Our Ref: P/74/17/HH

**Town & Country Planning Act 1990 (as amended)
Town & country Planning (Development Management Procedure) (England) Order 2015
Application for Householder Planning Permission**

Development Conservatory to rear.
Location 11 Laurel Drive Pagham

EXISTING ELEVATIONS

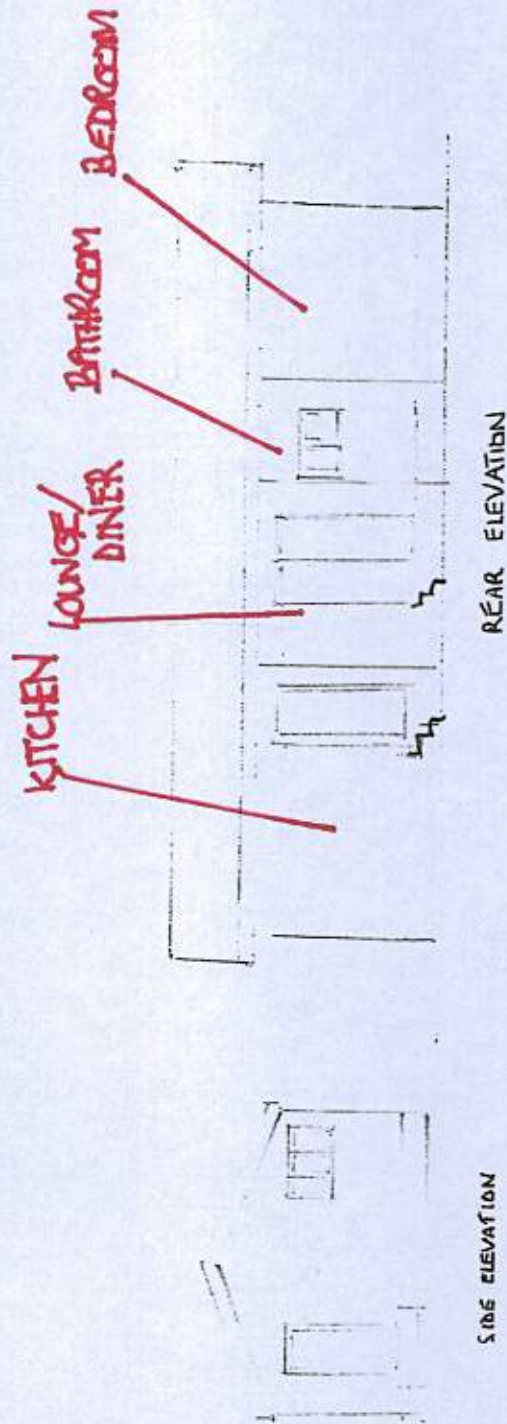
The scale on the elevations you provided (1:100) do not scale wiht the scale bar provided. Please ensure all plans scale correctly.

Existing

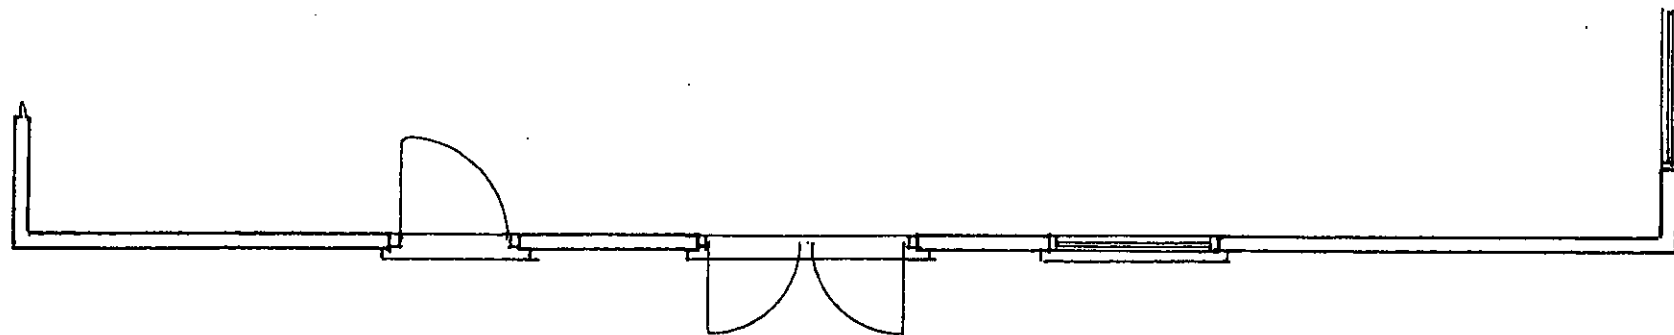
Please submit 1 electronic or 3 paper copies of clearly labelled existing and proposed floor plans at a scale of 1:50 or 1:100. Further details can be found in the National Validation Requirements.
